# CITY OF ALBUQUERQUE

August 30, 2021

**Re: Chase Bank**  
**11004 Montgomery Blvd NE**  
**Traffic Circulation Layout**  
Engineer's Stamp **08-24-2021** (G21-D018A(B))

PLOT DATE
08/21/21
DRAWING SCALE
1" = 20'
PROJECT NUMBER
CD21003
SHEET NUMBER

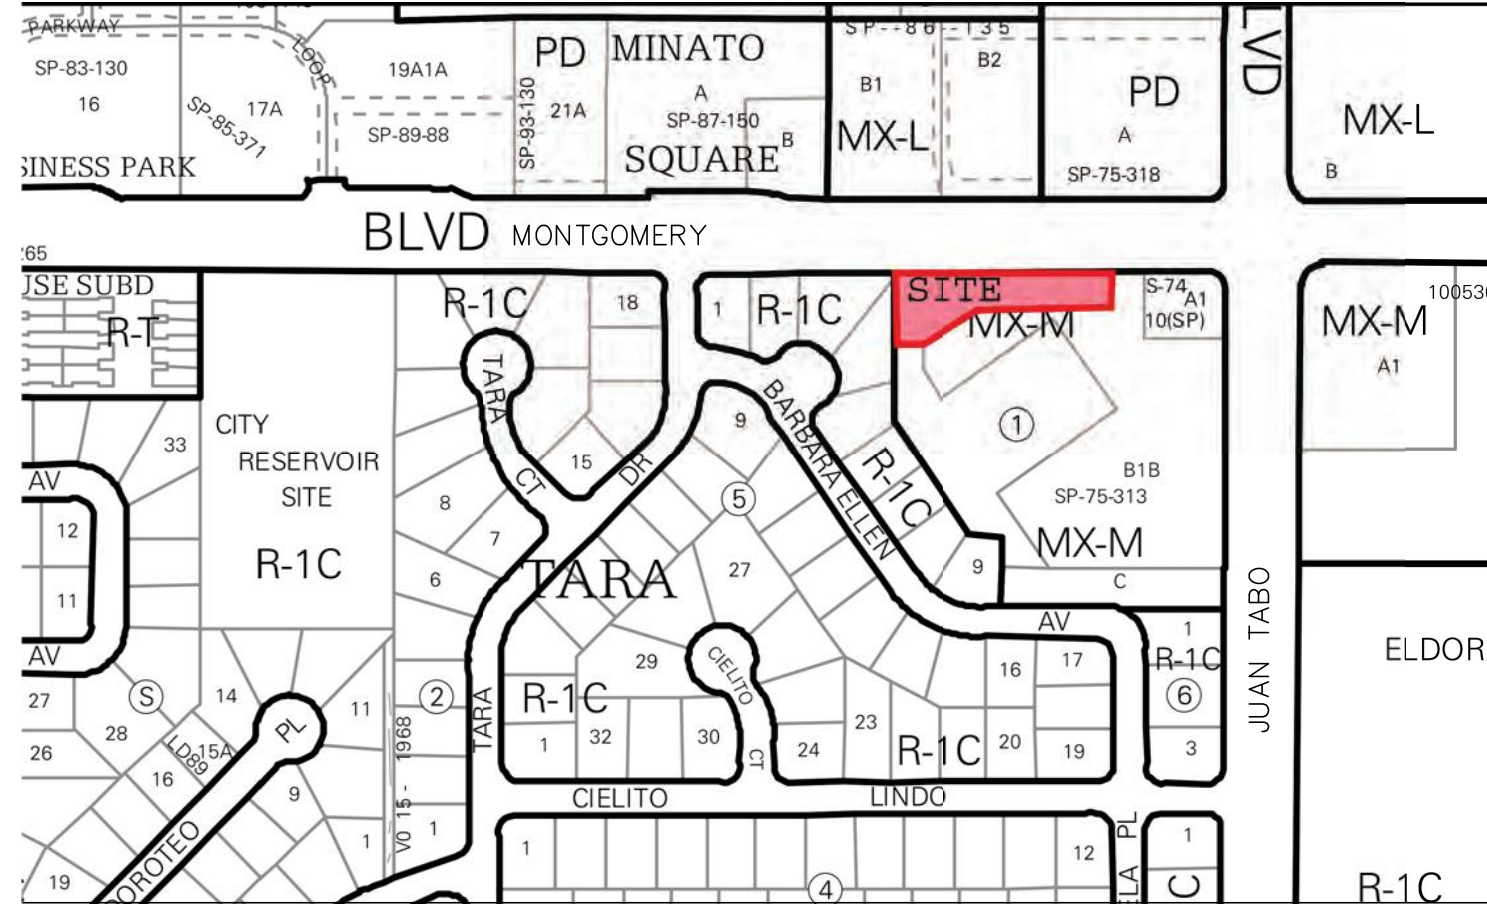
1. Provide the **receipt for the resubmittal fee**. This is your responsibility not the City's per your response.
2. **Sheet C1.02 (Proposed ADA parking stall infrastructure):**

- Proposed parking stalls will need to have an accessible route (**6ft wide ADA pedestrian pathway**) from access aisle to front entrance of building.

- ADA accessible pedestrian pathway should not be placed behind parking space or adjacent to a vehicular way. **Vehicle and pedestrian/wheel chair conflicts should be avoided as much as possible and will not be allowed.**

4. An **Approved FD plan** will need to be provided.
5. Per the IDO, a **6 ft. wide** ADA accessible pedestrian pathway is required from the public sidewalk to the building entrance but partial shown is a 5ft width from public sidewalk to proposed ADA access aisle ramp.

ADA RAMP DETAIL
N.T.S.

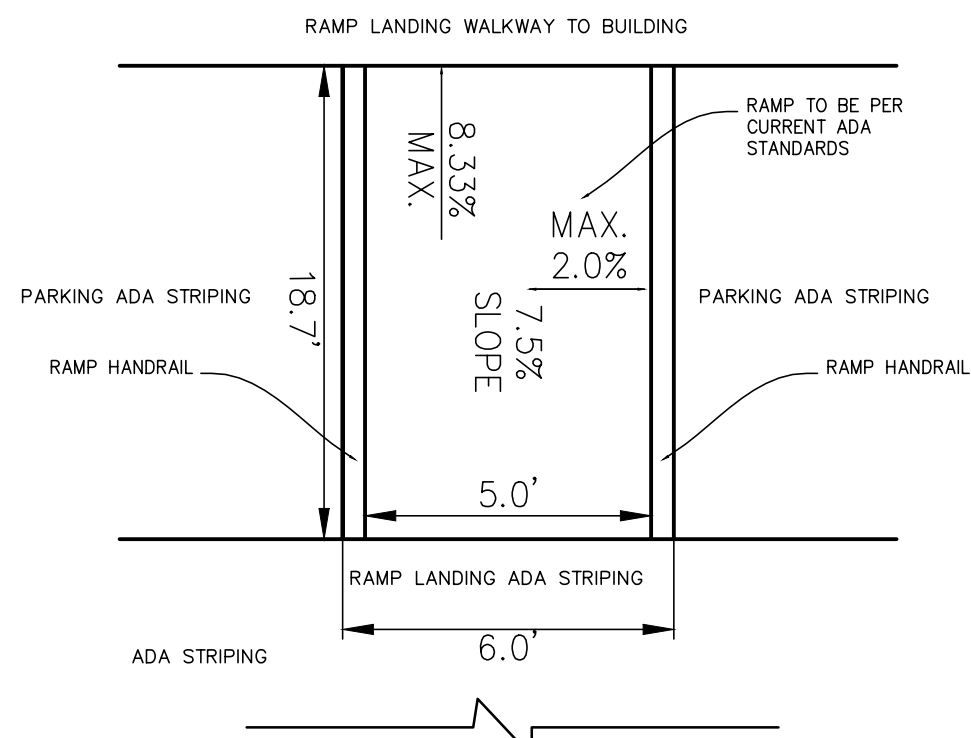
- The proposed ADA ramp detail for access aisles will need to be modified to provide a 5 ft x 6 ft landing (Slope 2%). The running slope shall be 12:1max. **This will need to be provide since ADA accessible pathway behind parking stalls is not allowed.**

RAMP HANDRAIL
DETAIL
N.T.S.

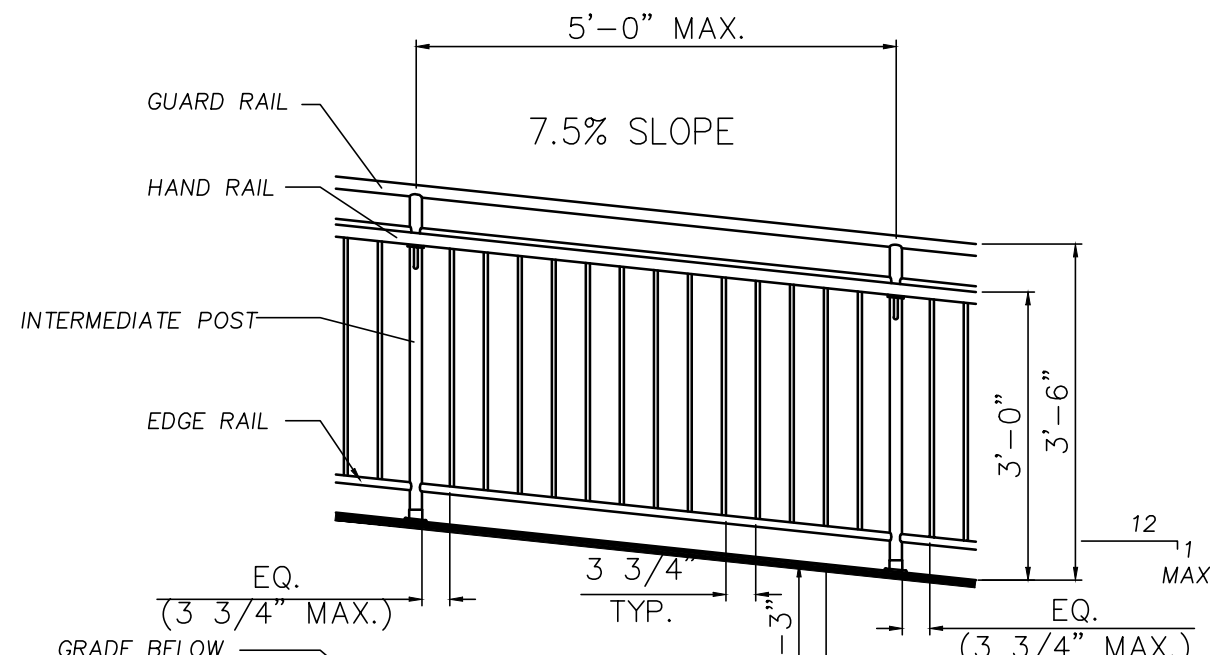
- **Ramp Handrail Detail:** Is the Edge rail 4 inches from bottom surface? If so, please provide this dimension.
3. The ADA accessible spaces must include an access aisle. **Van accessible aisles should be 8ft wide**; all others should be 5ft wide
